Meeting note

File reference	EN020015
Status	Final
Author	Siân Evans
Date	19 July 2017
Meeting with	National Grid
Venue	Temple Quay House
Attendees	The Planning Inspectorate Chris White (Infrastructure Planning Lead) Tracey Williams (Case Manager) Siân Evans (Case Officer) Hannah Pratt (Senior EIA and Land Rights Advisor) Alison Down (EIA and Land Rights Advisor) Dave Anthony (Lawyer) National Grid Eloise Frank (Project Engineer/ DCO Manager) Jacqui Fenn (Senior Consents Officer) Annette McNally (Lead Lands Officer) Simon Best (Internal Legal) James Parker (External Legal) Andrew Connolly (Lead Project Manager)
Meeting objectives	North Wales Connection Project update
Circulation	All attendees

Creator: TF	Date: 15/06/2018	Checker: SF	Date: 15/06/2018	Approver: JKS	Date: 15/06/2018
Document Type: FIGURE	Scale: 1:5,000	Format: A3	Sheets: 2 of 29	Rev: A

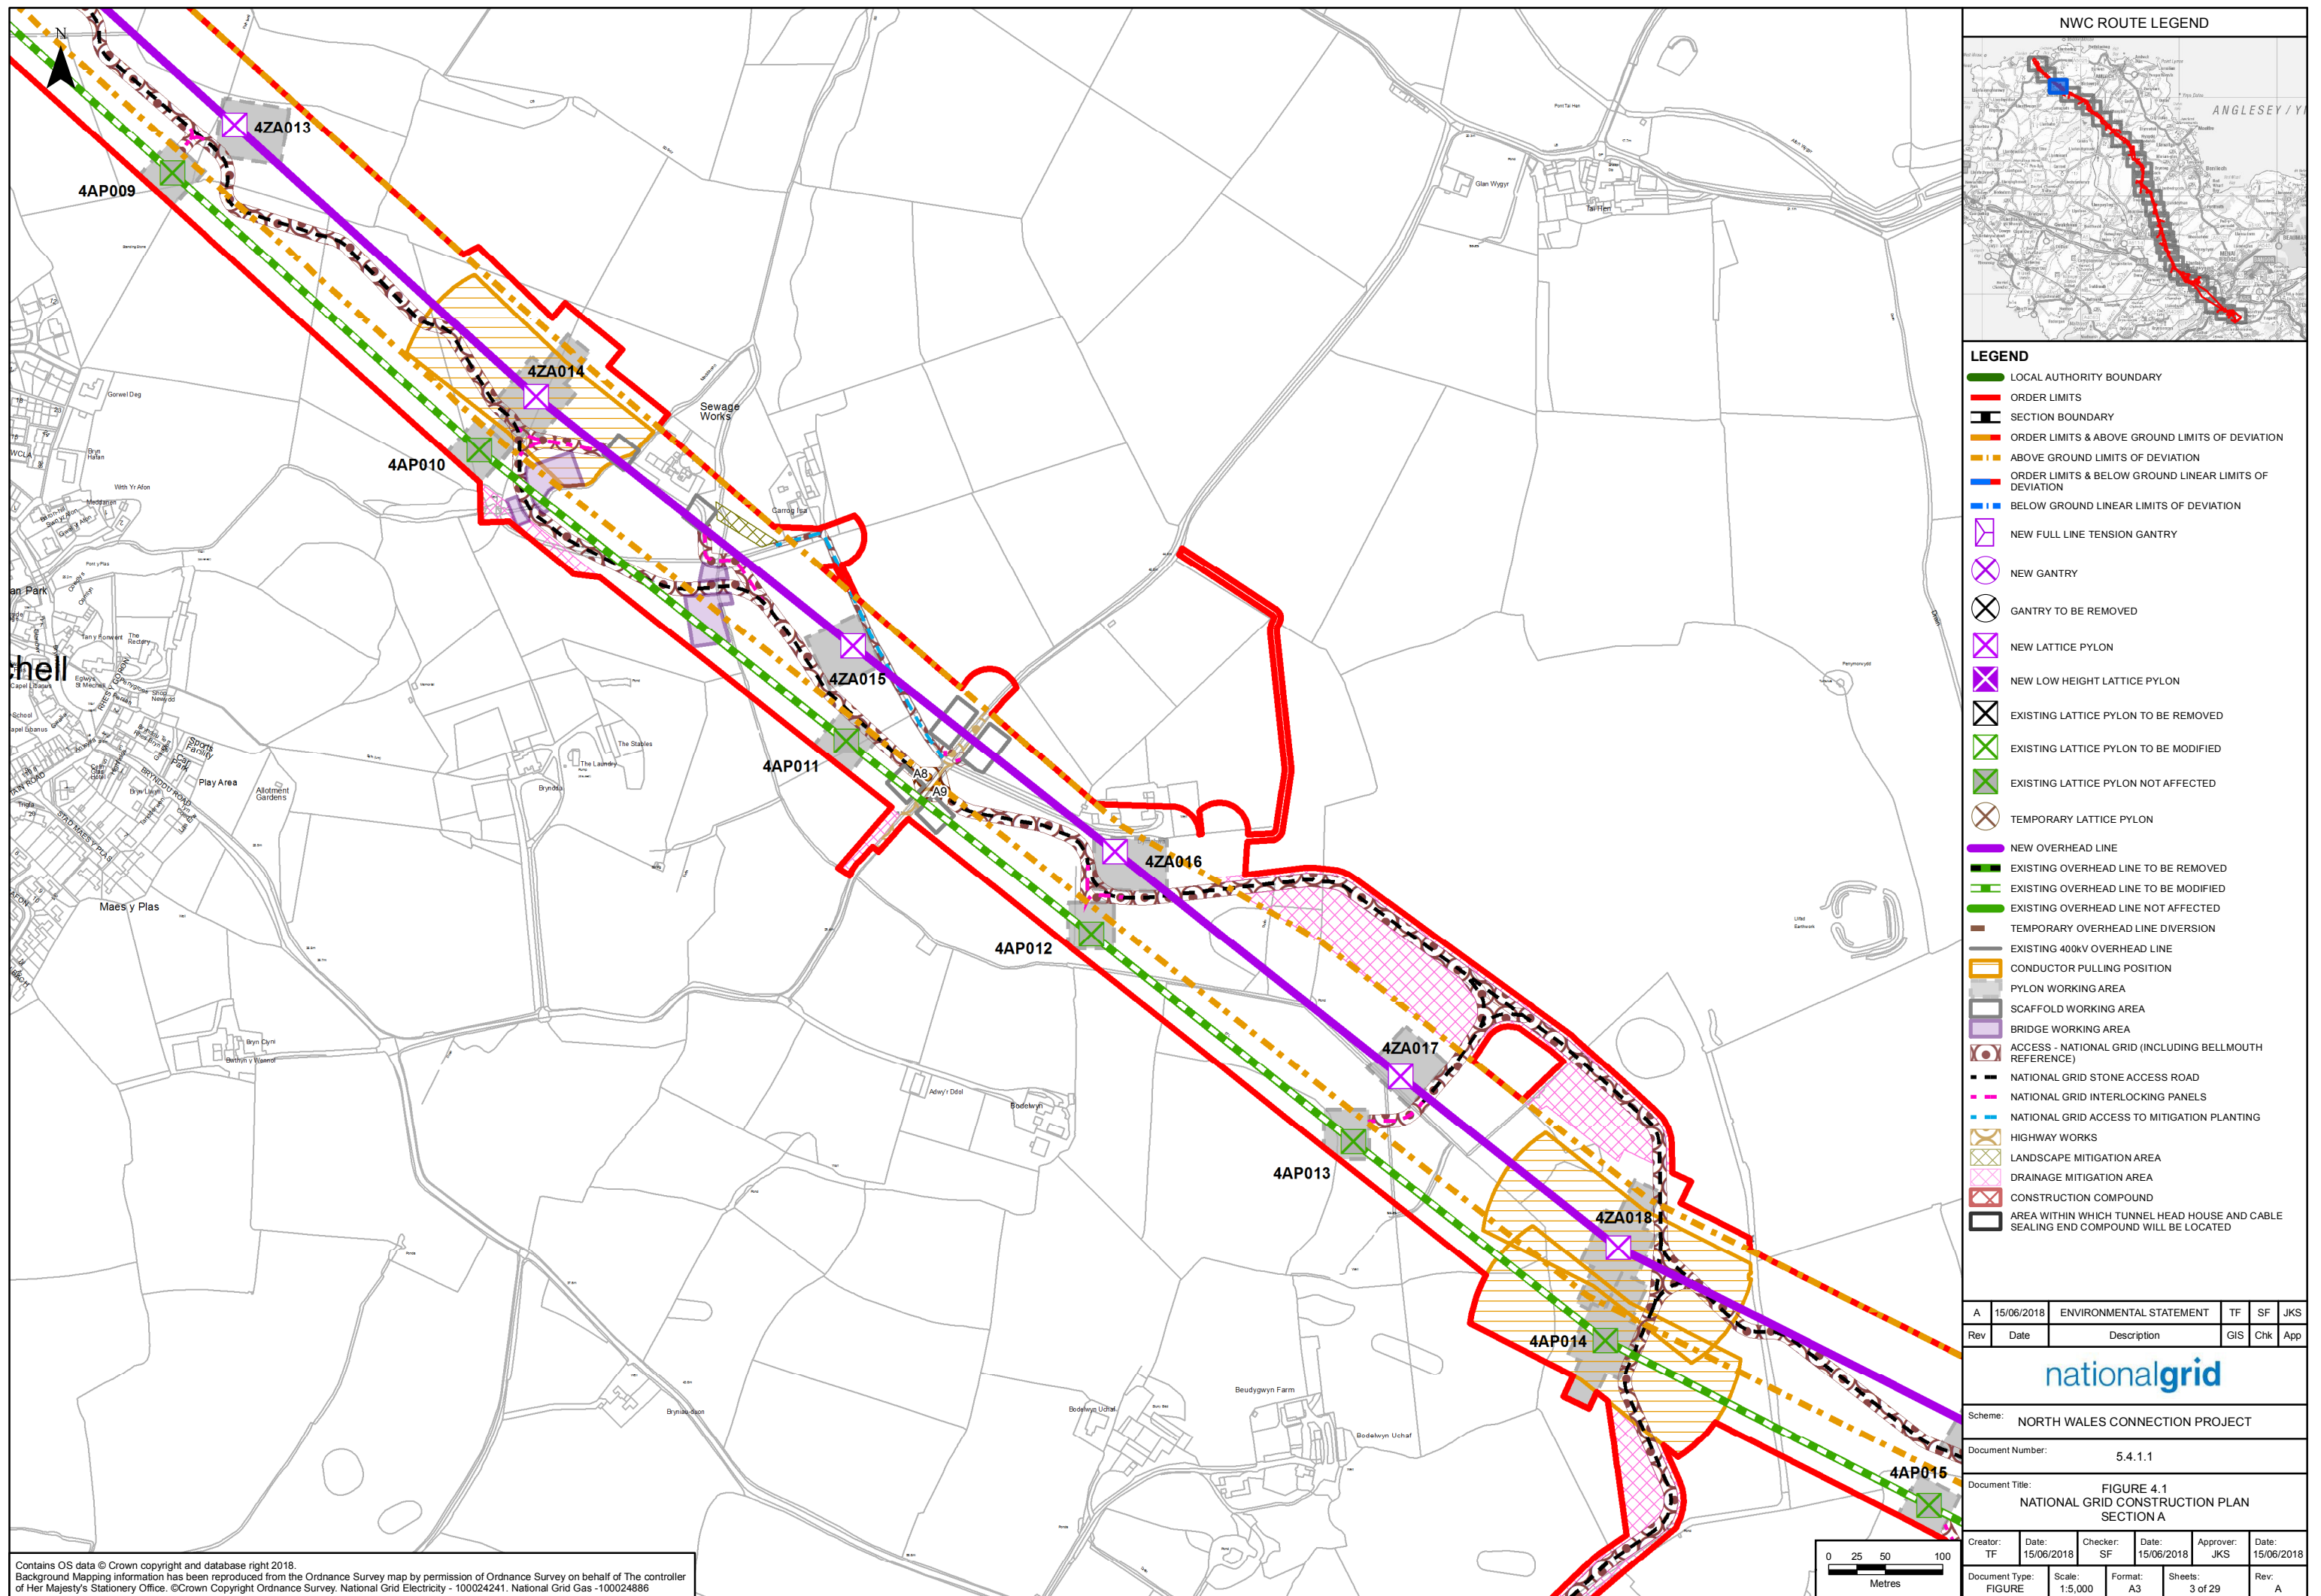
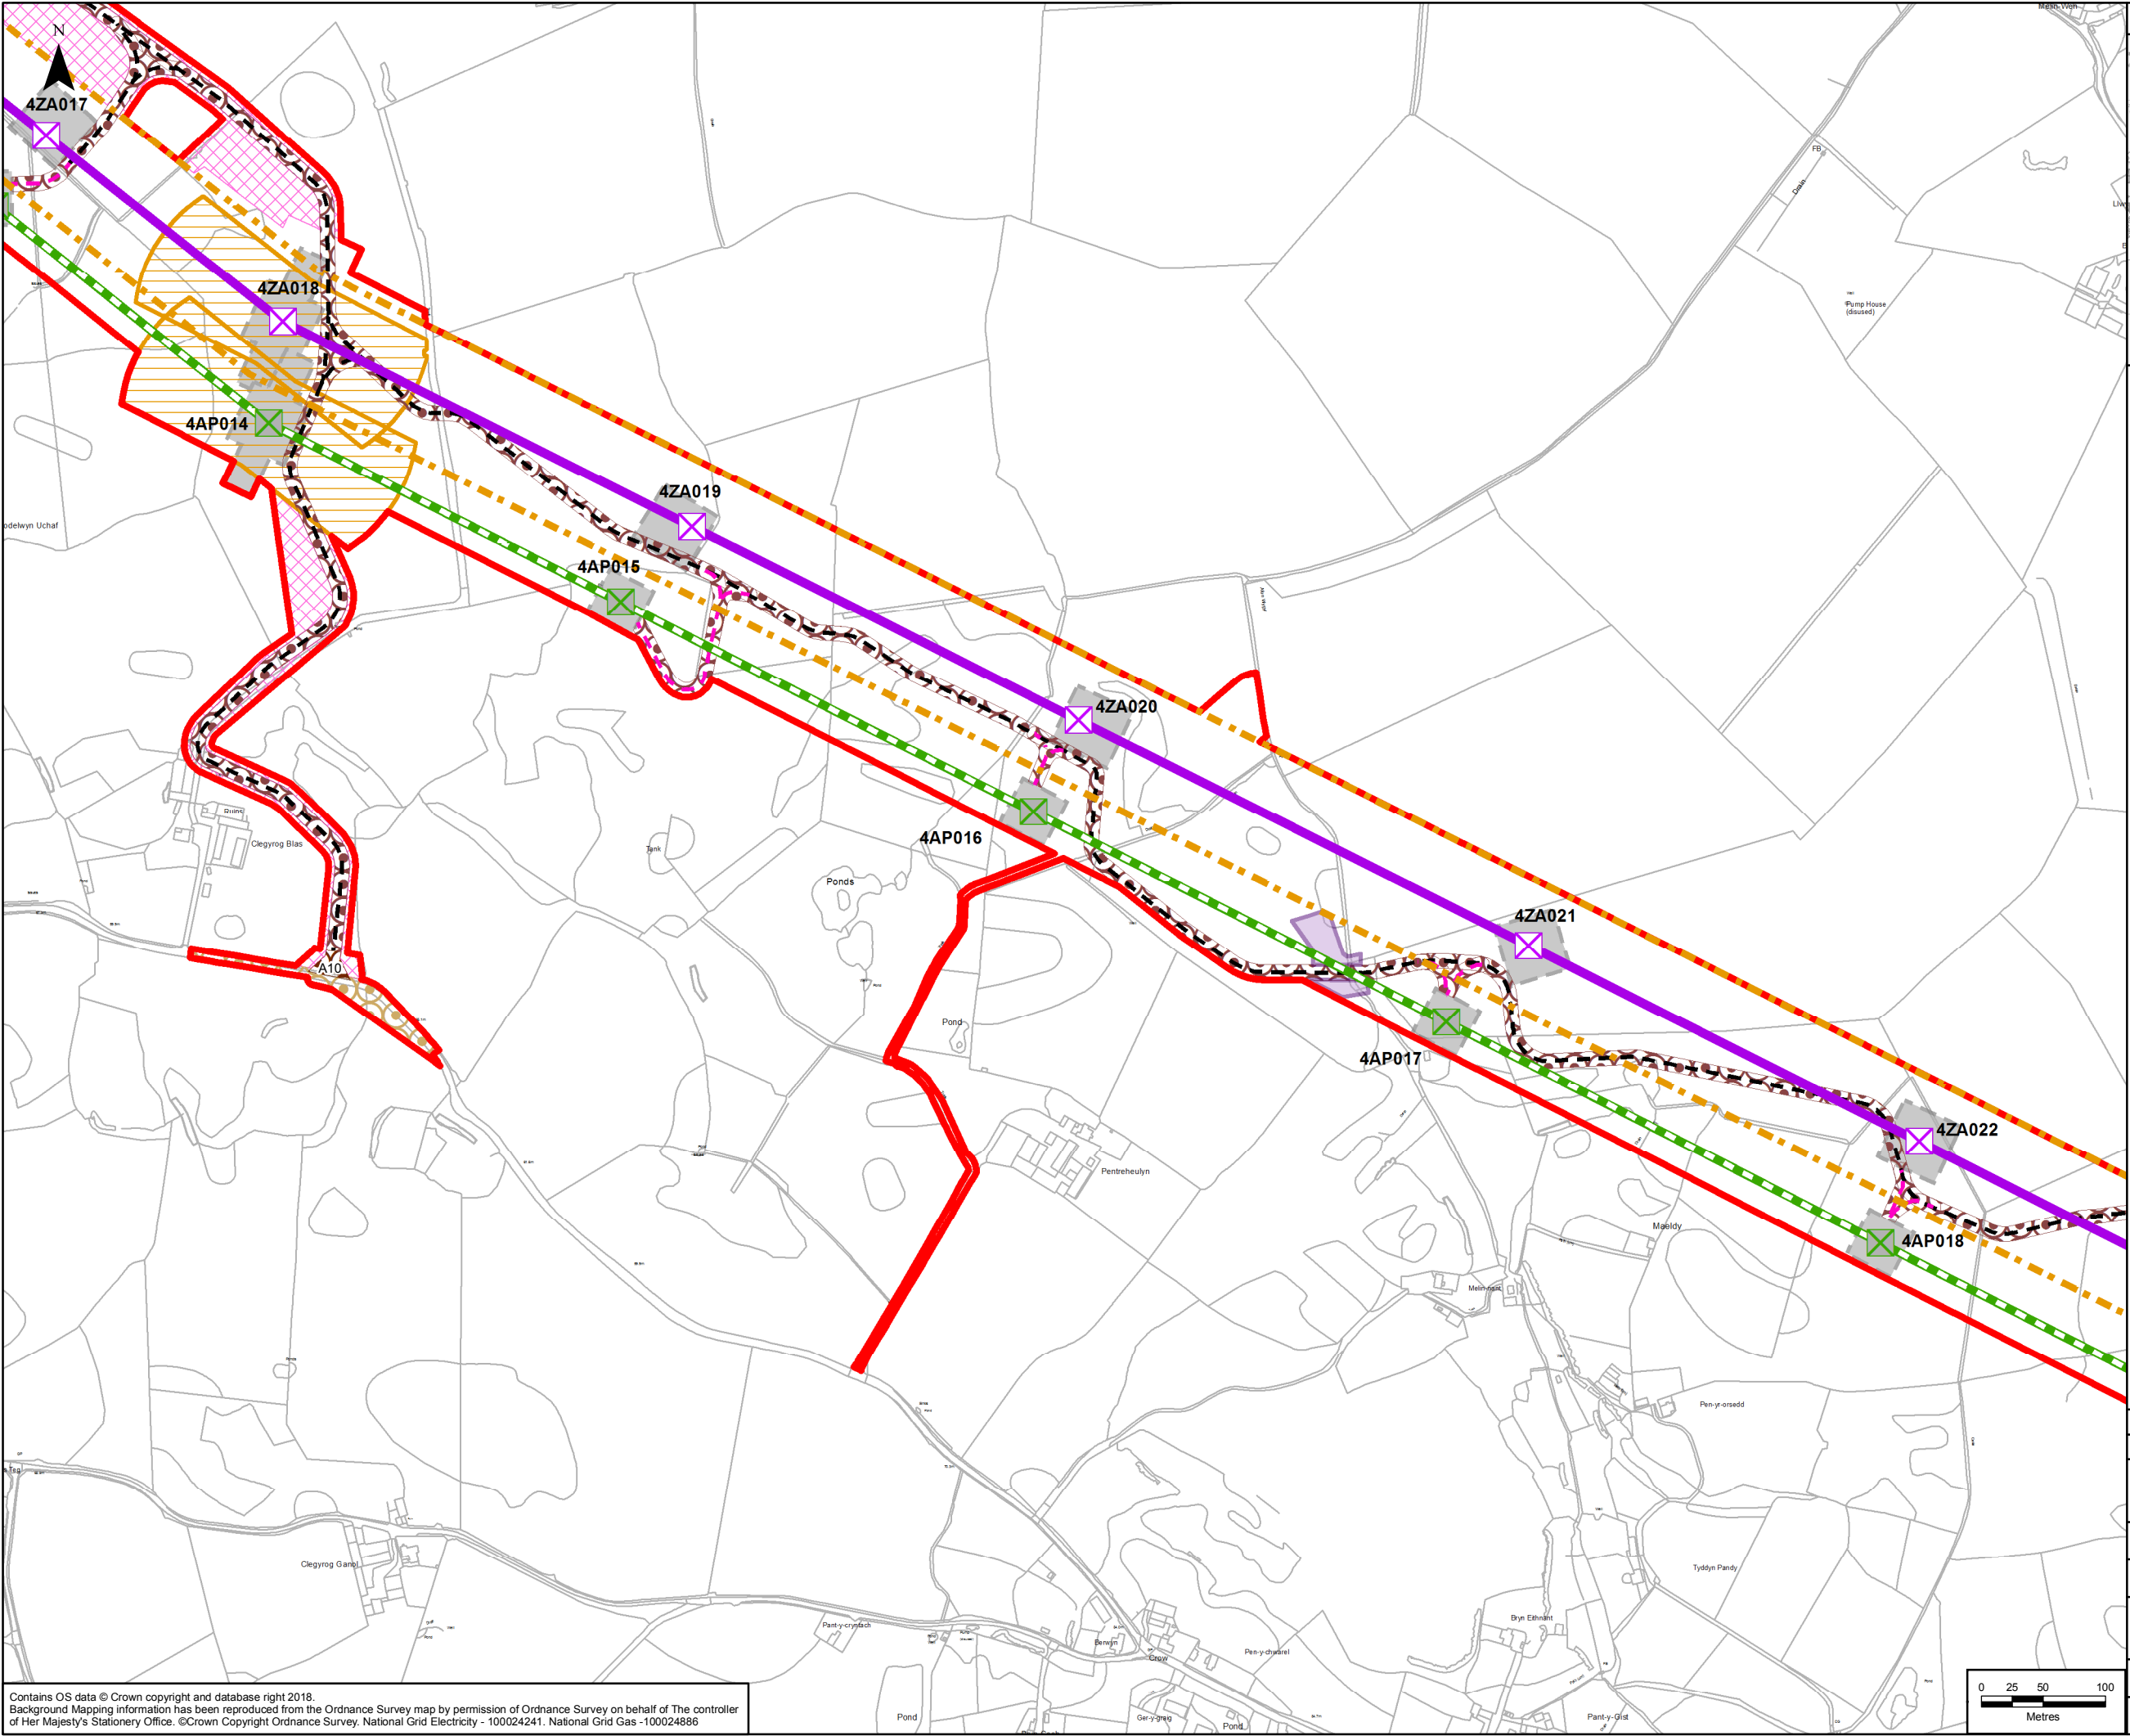
- The Works Plans show a number of accesses along the route. The Inspectorate queried what works are required and whether they need to be numbered within the authorised development or included as associated development.

- The 'new gantry' (full line tension) and 'new lattice pylon' symbols used on the Works Plans are very similar. It would be helpful if different symbols are used to clearly differentiate between the two.
- The Inspectorate advised the Applicant to note that at Acceptance all of the plots in the Book of Reference are checked against the Land Plans.
